ENVIRONMENTAL ASSESSEMENT REPORT
SECTION 75W APPLICATION FOR MODIFICATION OF PROJECT APPROVAL
SUBMITTED TO NSW DEPARTMENT OF PLANNING AND INFRASTRUCTURE

Stage 1 of the extension of Shore school campus onto the Graythwaite site

MP 10_0150 (MOD 1)

12 MARCH 2013

Drawing Title
 LANDSCAPE TREE PLAN

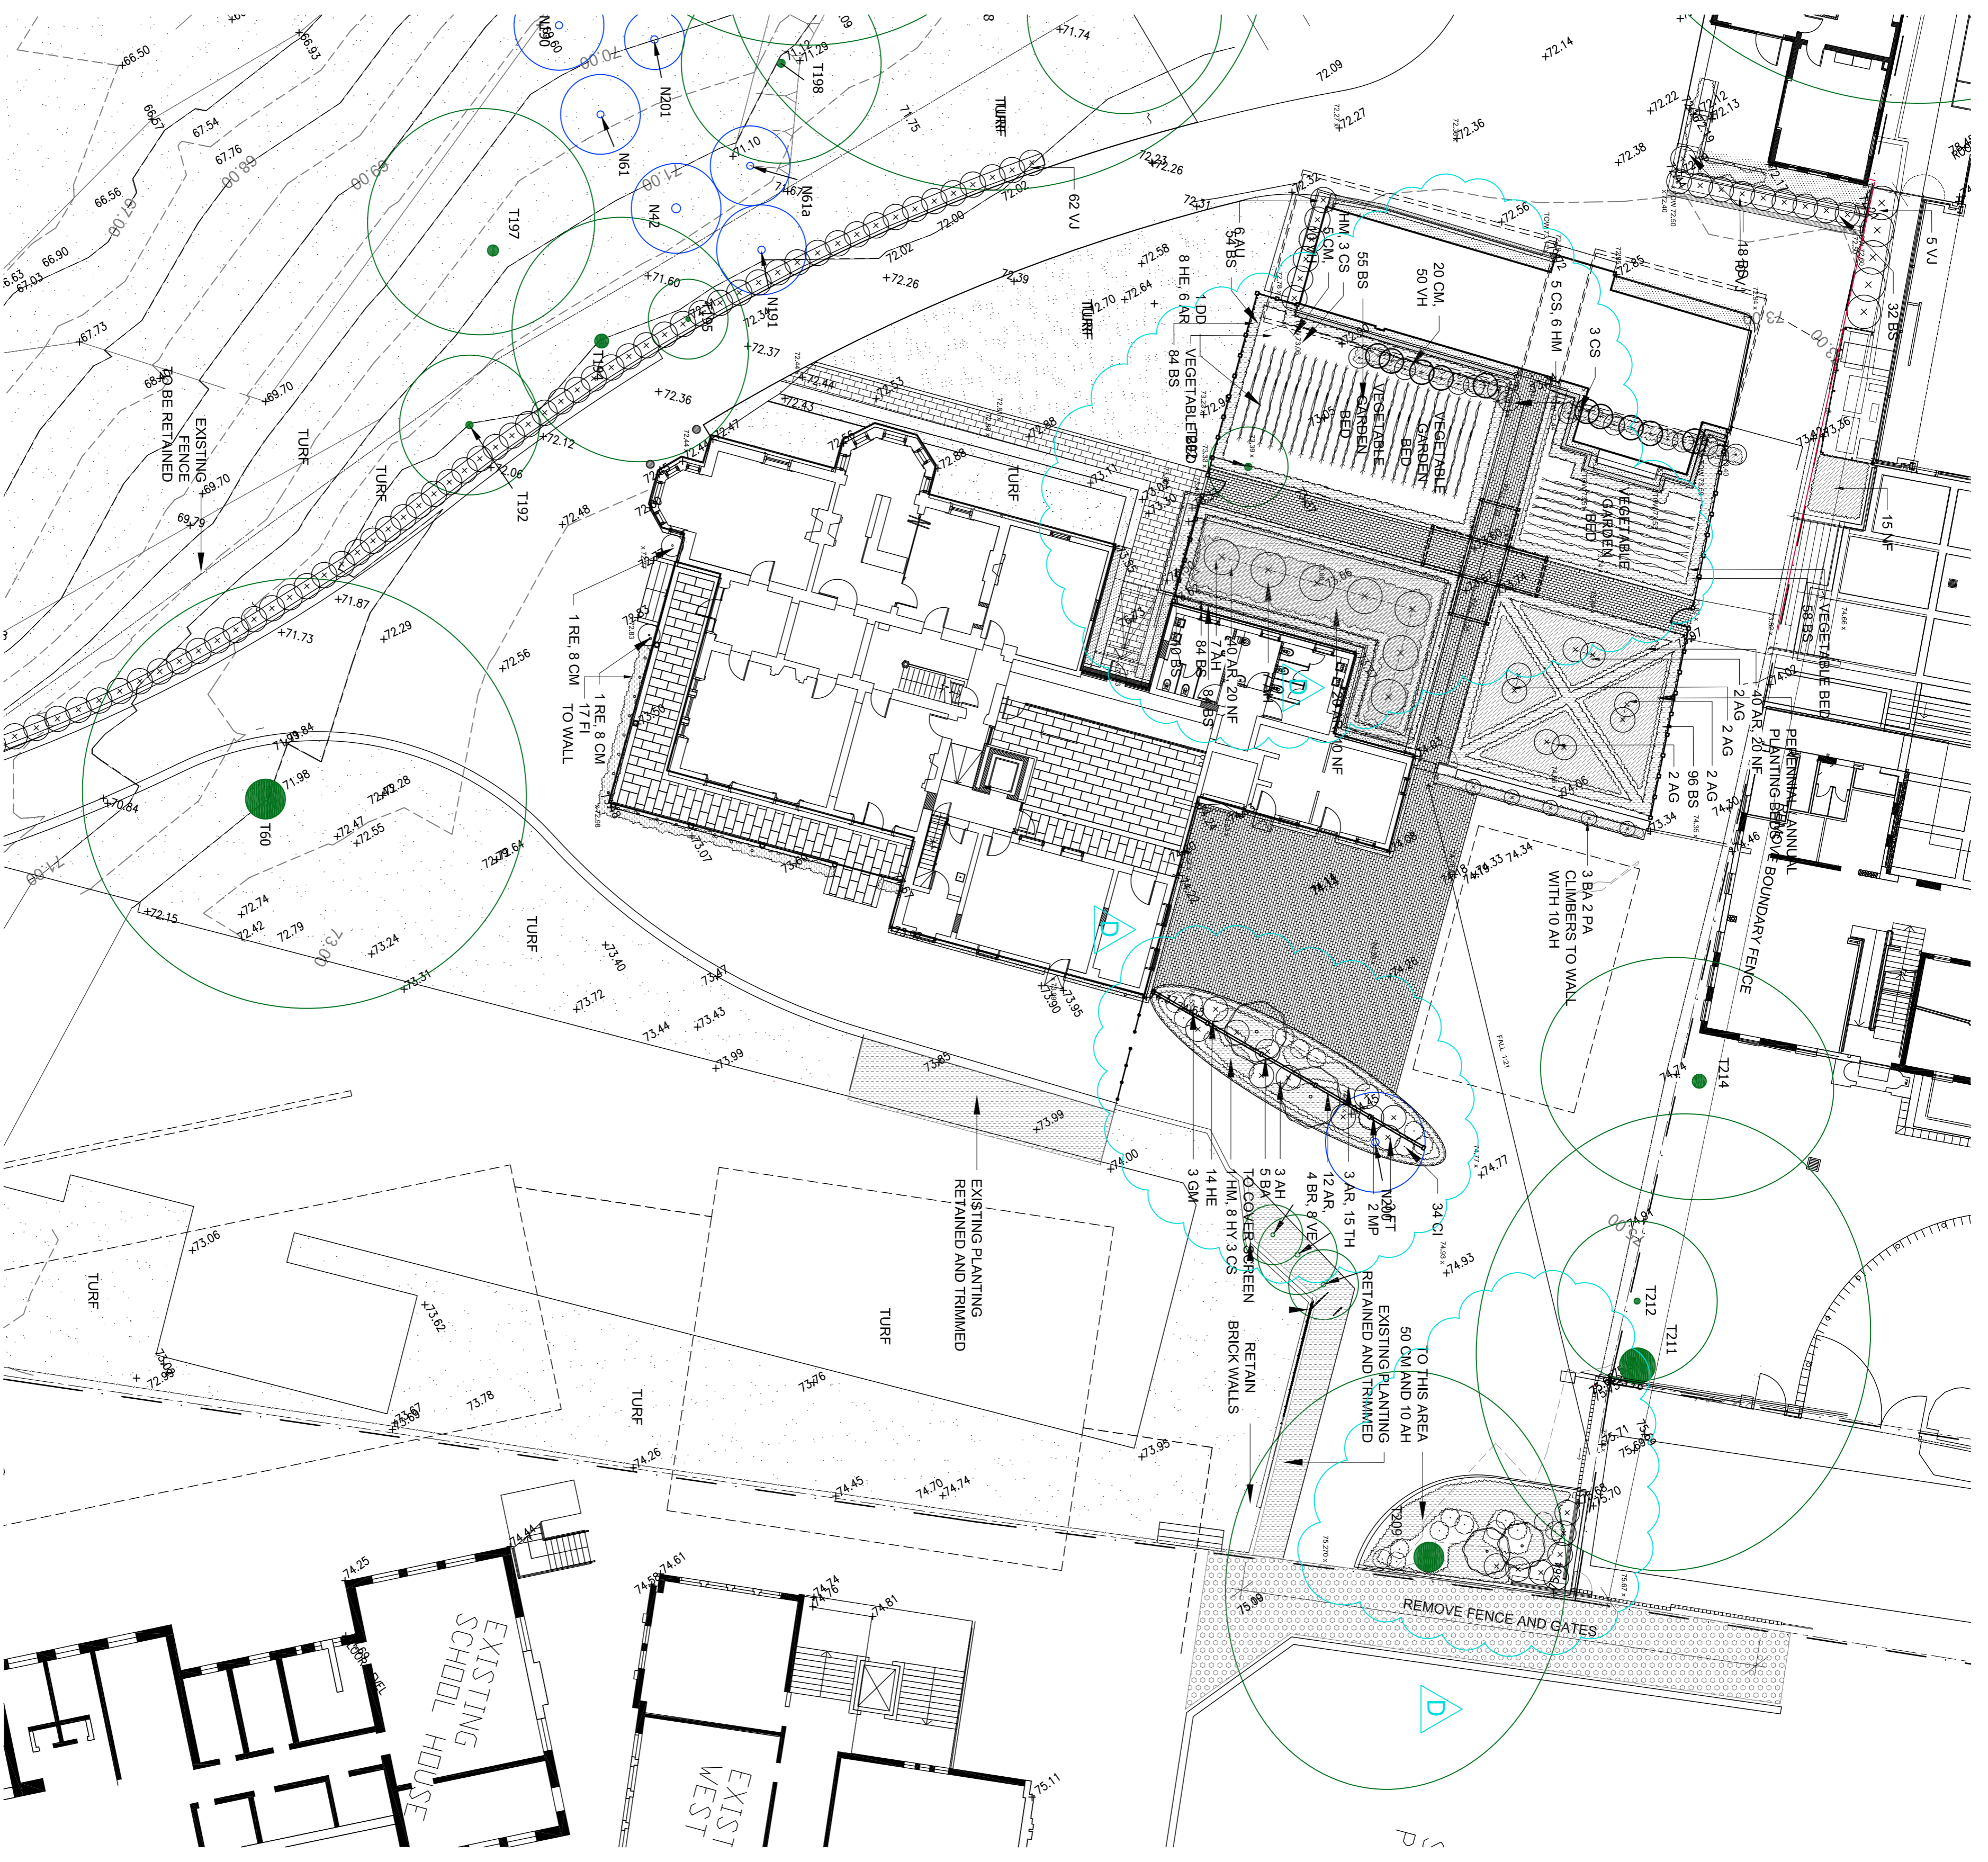
Four Camphor Laurel trees (tree numbers T13, T30, T34 and T37) at the lower section of the driveway are proposed to be removed and replaced with a Brush Box variety (a species more consistent with the approved landscape plan for Graythwaite).

The four trees to be removed have wide spreading root networks which are causing uplifting and damage to the driveway kerb, gutter and asphalt. Their removal and replacement with Brush Box, which have less invasive root networks, is necessary in order to create a smooth, even gradient in the road surface.

Drawing Title  
**SITE PLAN**

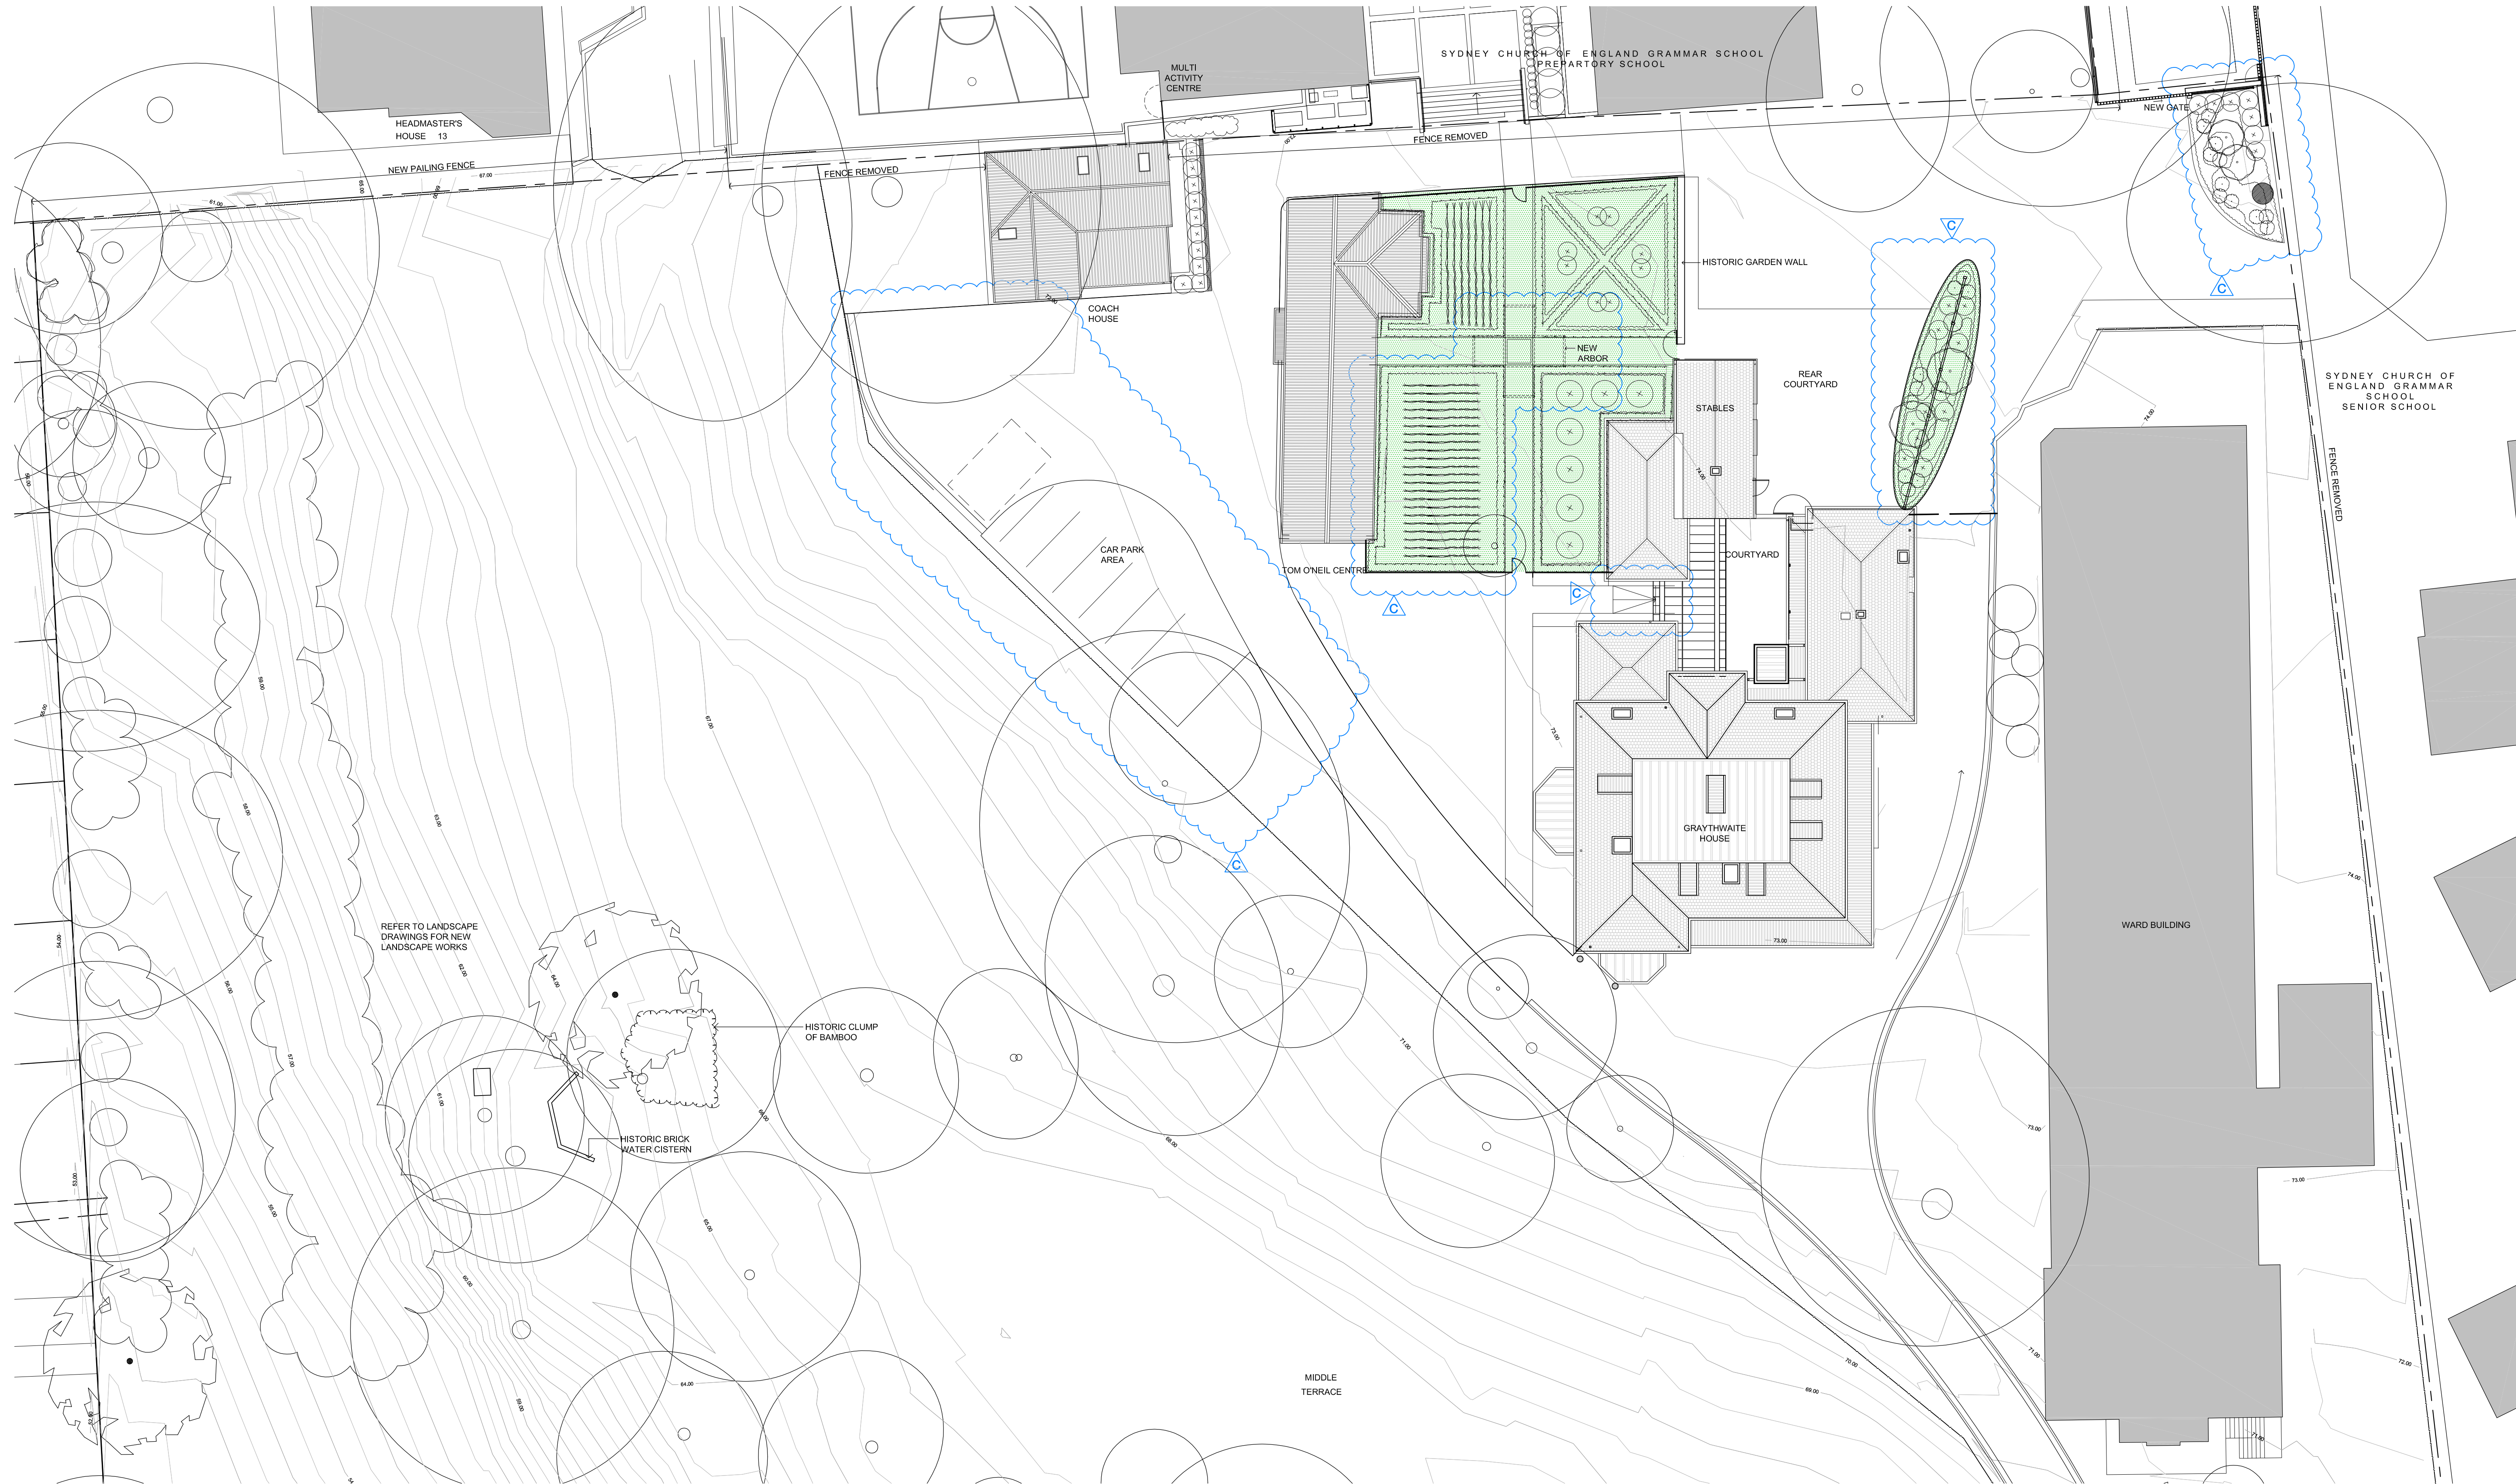
- Installation of a hydrant tank and enclosure on the eastern side of the driveway
- New garden arbour within the proposed formal garden to the east of the Tom O'Neill Centre
- Brick drain along either side of the driveway
- Additional timber paling fences at the substation and along the north-west site boundary
- New pathway on the eastern boundary providing pedestrian access to the adjoining Senior School
- Additional planting along the side boundary to Kailoa (44 Union St)
- Removal and replacement of Camphor Laurel trees at the bottom of the driveway with *Brush Box*.

Drawing Title
**GRAYTHWAITE HOUSE
BASEMENT AND GROUND FLOOR PLANS**

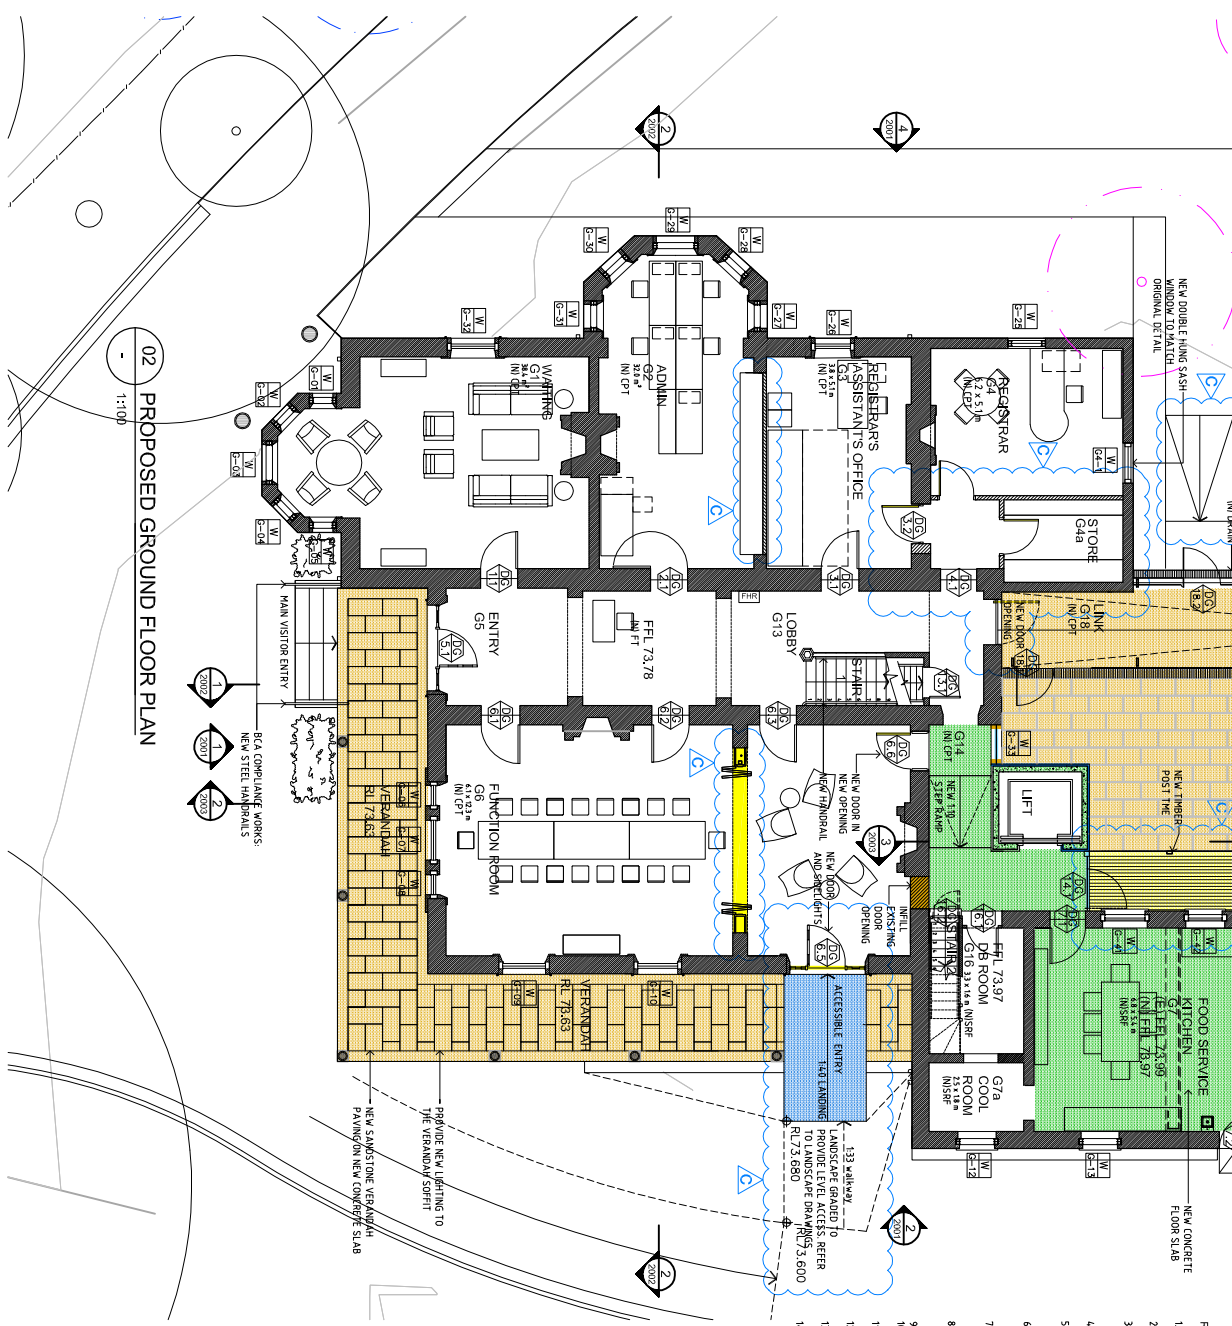
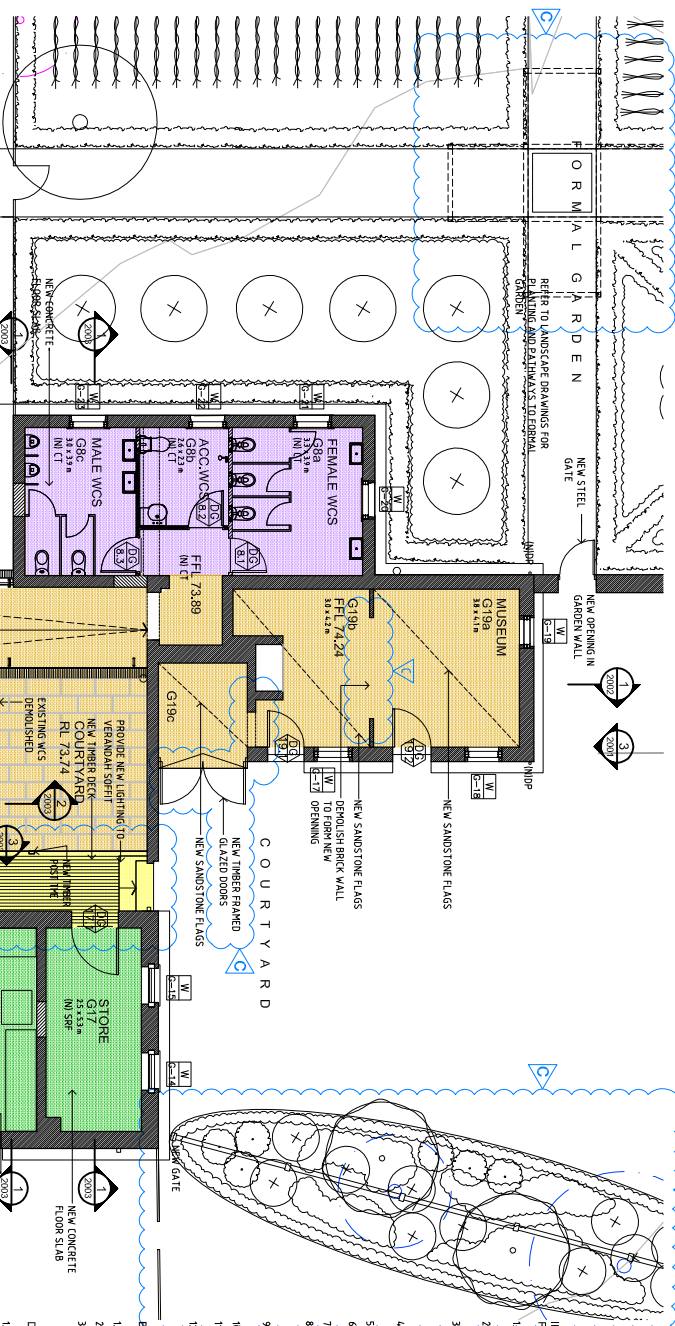
- Demolition of non-original timber stairs and installation of new BCA compliant basement stairs and fire-rated enclosing lobby, required for Code compliance.

- G13 Entry Hall: demolition and replacement of deteriorated, structurally unsound timber framed section of floor
- Rooms G2, G3, G4 and G6: removal of an original door (G4), installation of new doors within an existing opening (G6) and new partitions (G2, G3 and G4)
- Stables Museum G19c: Forming of an opening with a sandstone wall and installation of new glazed doors to form an airlock
- Stables Museum G19a and b: Partial demolition of non-original internal brick to enlarge an existing opening.
